Y/142/21/A

Land East of Drove Lane Yapton BN18 0EB

Various advertisements in various locations

Martyn White
Principal Conservation Officer,
Planning Services

| 2 Static Banner Flag | 5 Secondary Sign Medium | 8 Secondary Sign Standard | 11 Secondary Sign Standard |

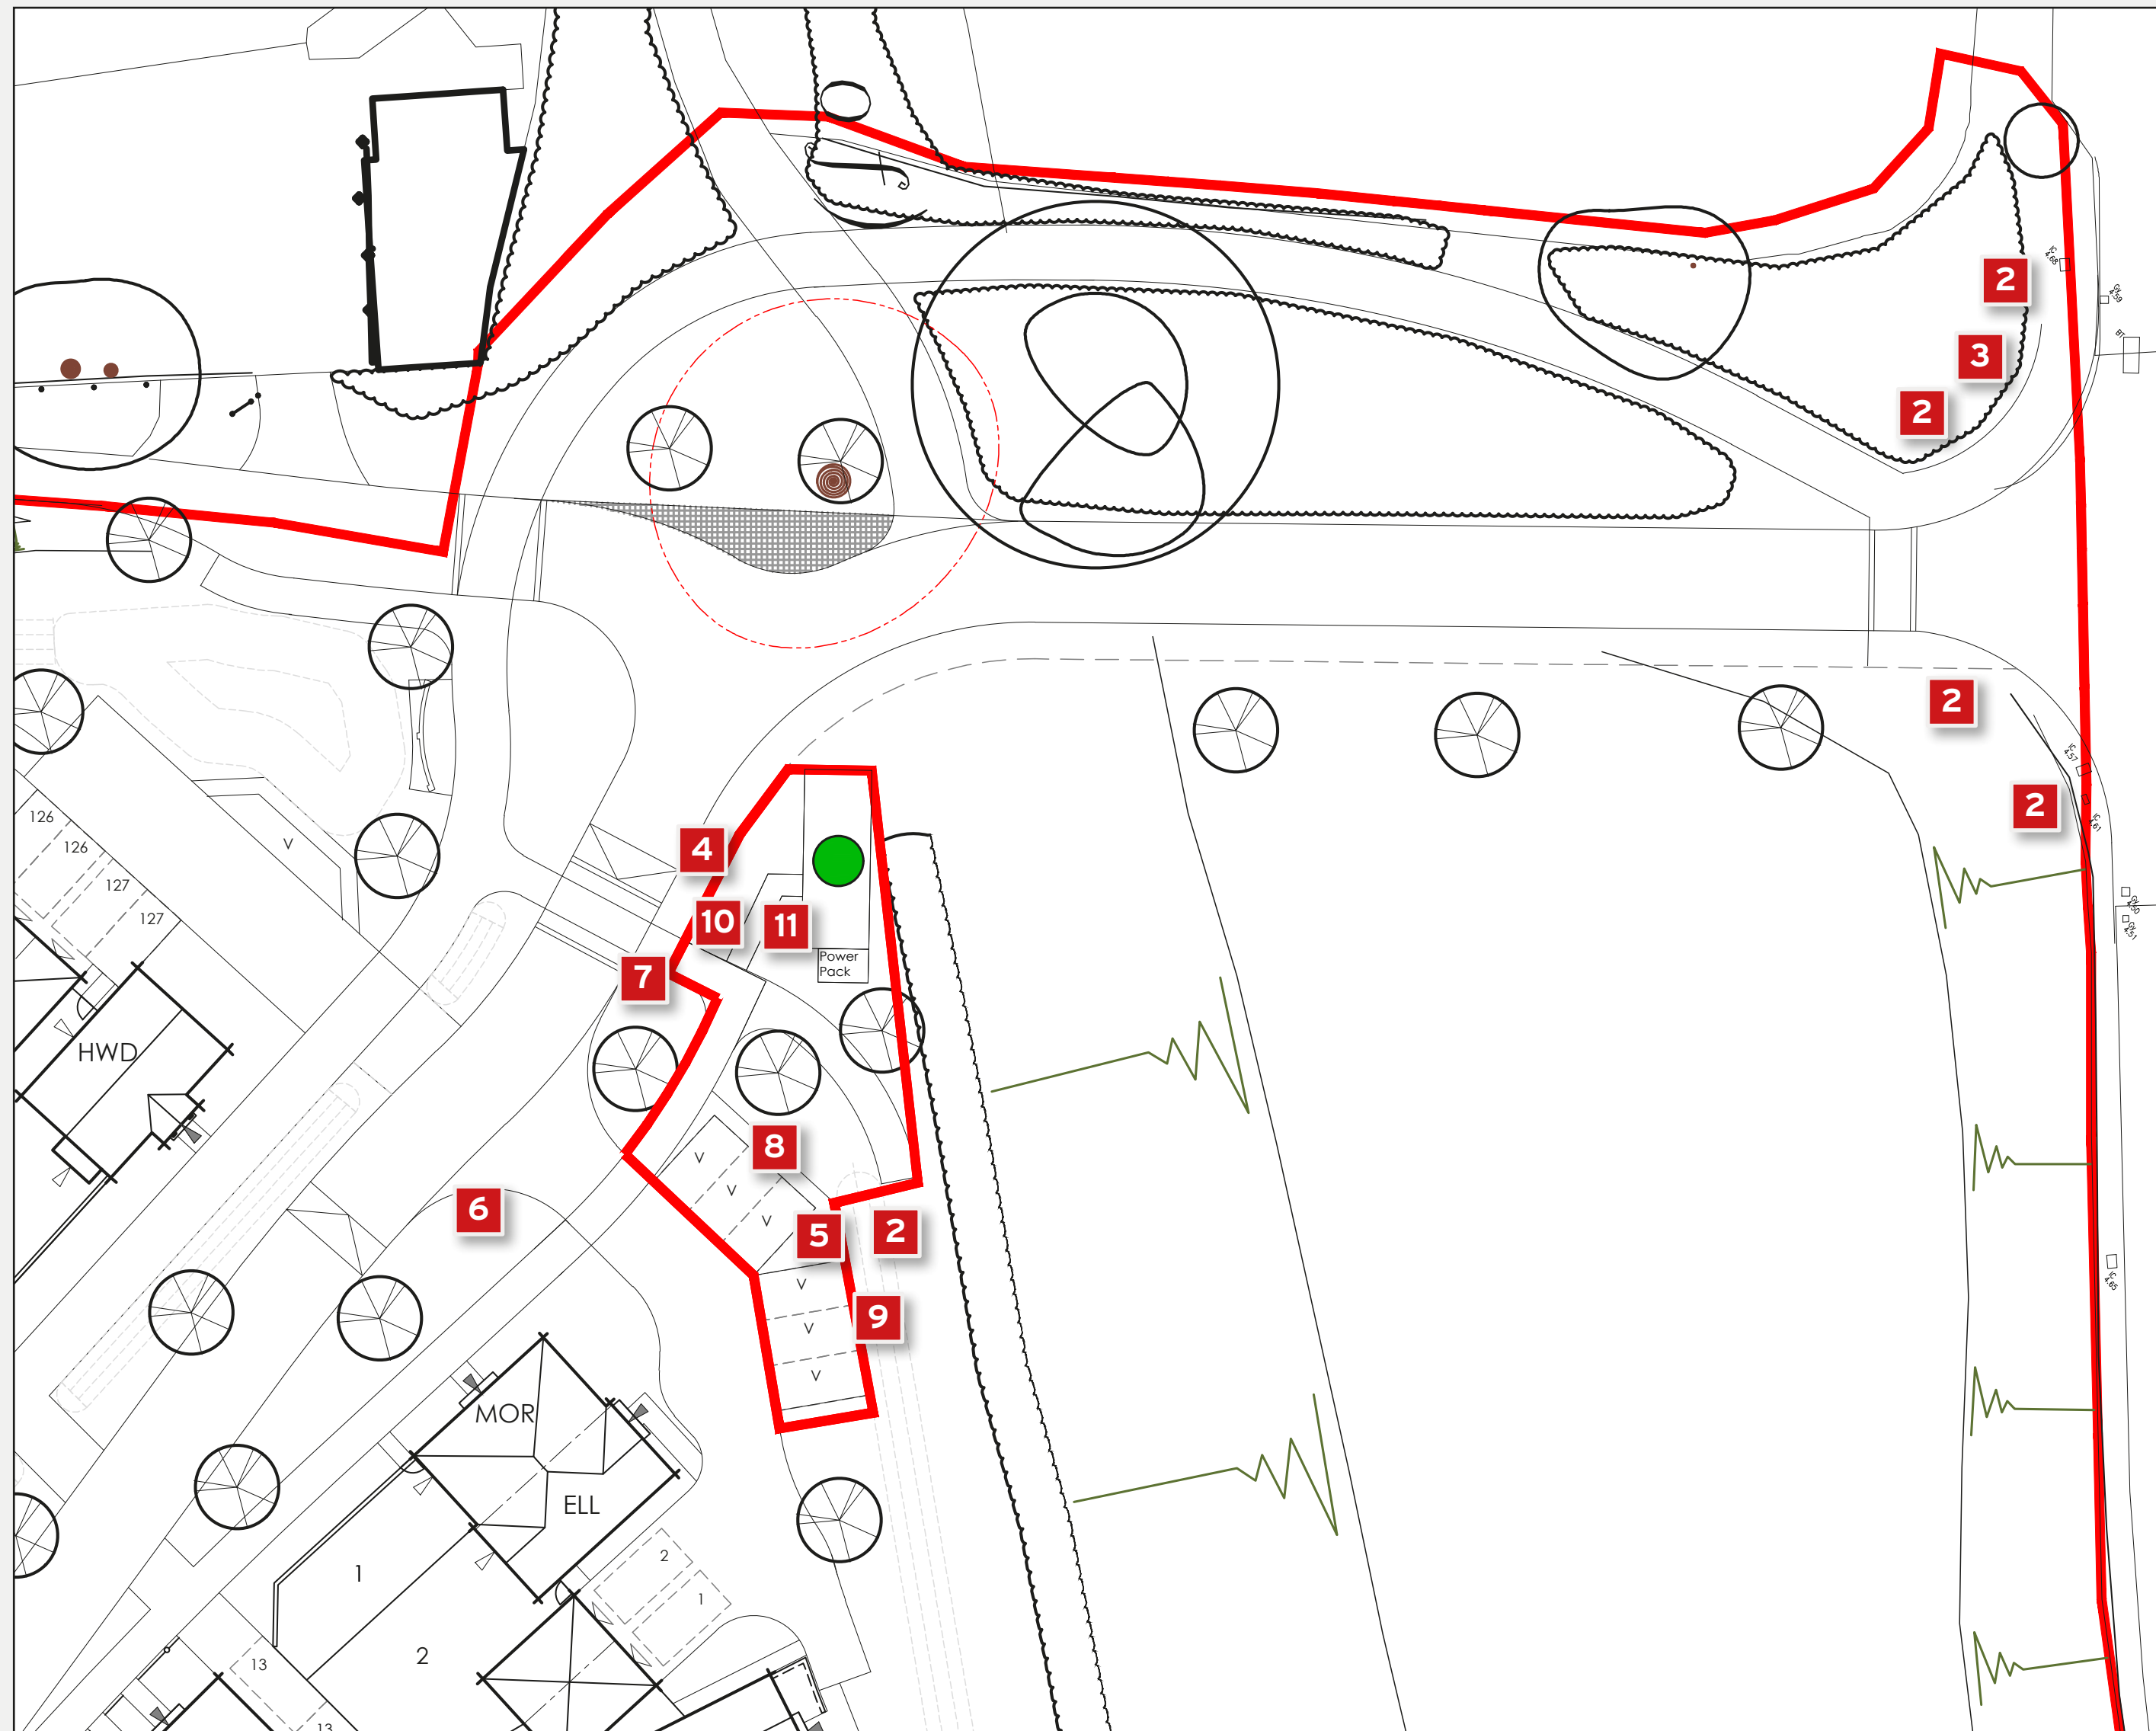
The proposal is for various advertisements in various locations within the proposed development site. The application includes a number of signs of differing sizes and appearances utilising the logo and colours of the developer. The majority of them are located around, or on, the sales cabin which is itself located mostly behind an existing mature hedgerow. This leaves five signs at the main entrance to the scheme which consist of four static banner flag stands and one main sign totem.

Whilst such signs are normally associated with a development such as this, there is some concern with the size of those closest to the conservation area. For instance, the static banner flag stands at just under 5 metres high and will be in four locations, all clearly visible from the conservation area/listed buildings. whilst the main totem would be approximately 4 m high and 1.5m wide. However, the lack of other signs at the entrance, along with some attempt at planting will mean that the impact of the signage will be somewhat reduced. Further, it is assumed that the signage is only to be present for a temporary period of time, which could be agreed as part of this application.

Item 2 - Quantity 5
STATIC BANNER FLAG POLE COMPLETE WITH DOUBLE SIDED FLAG

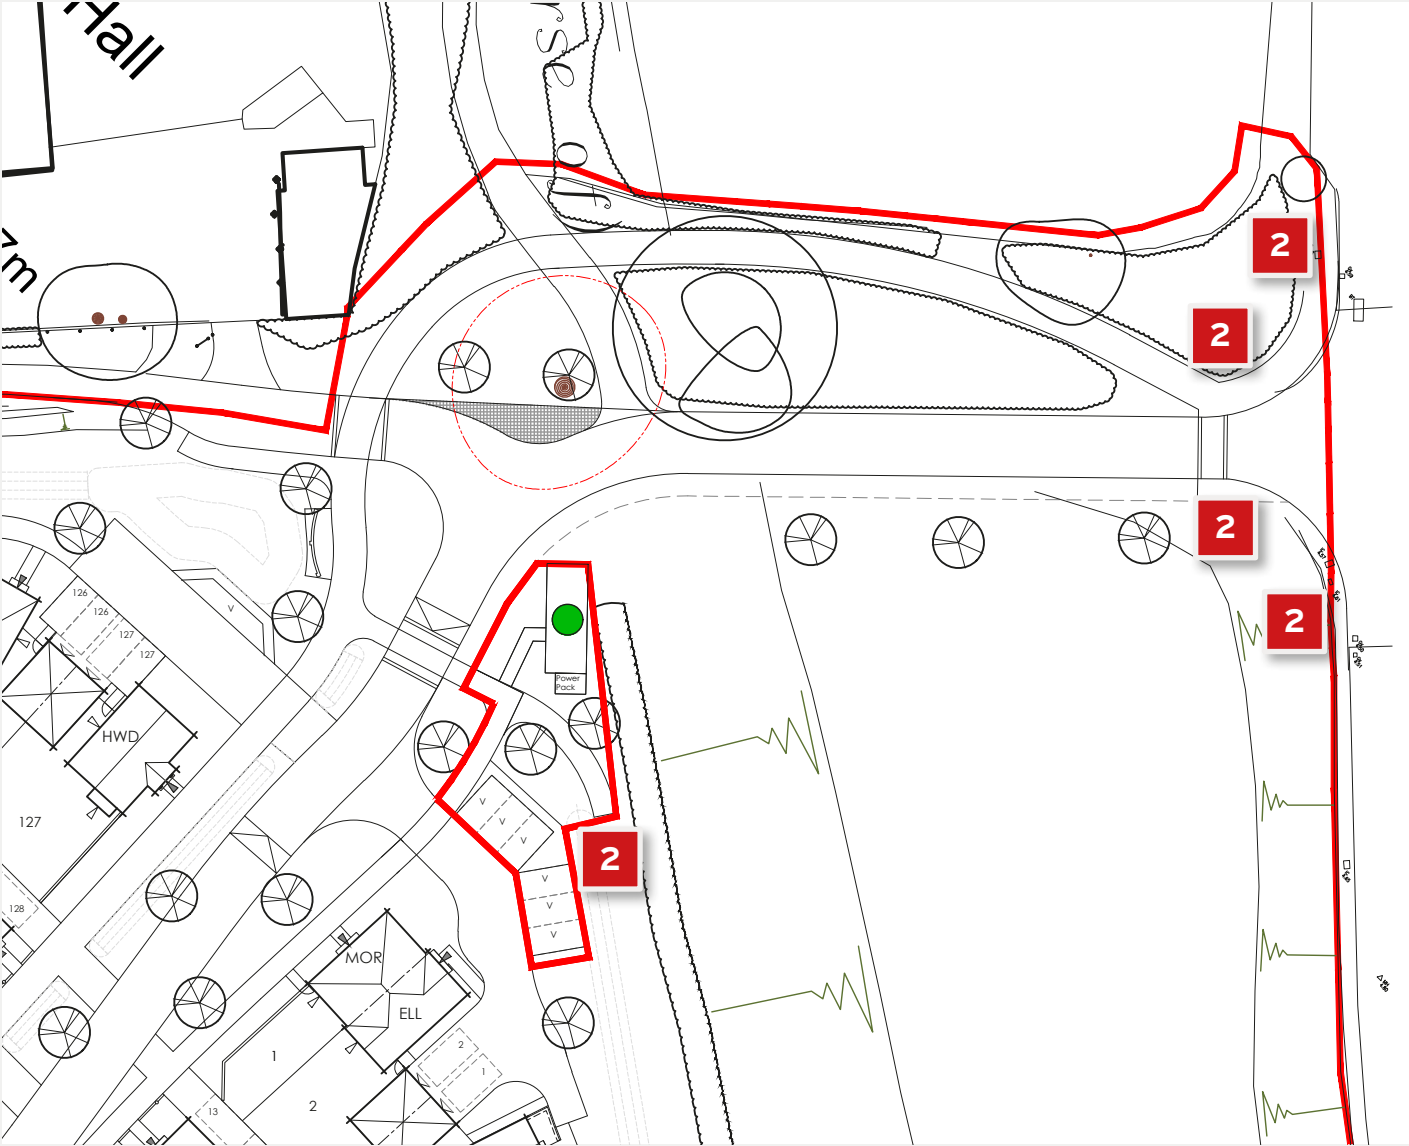
Having visited another site by the same developer it appeared that the static banner flag poles there had a 'wood effect'. This seemed to be more appropriate for that location (which adjoins a conservation area) and could be an improvement over the white metal poles which are proposed as part of this application. Would it be possible for the applicant to consider this alternative design/material? if so the impact of the signage would be reduced.
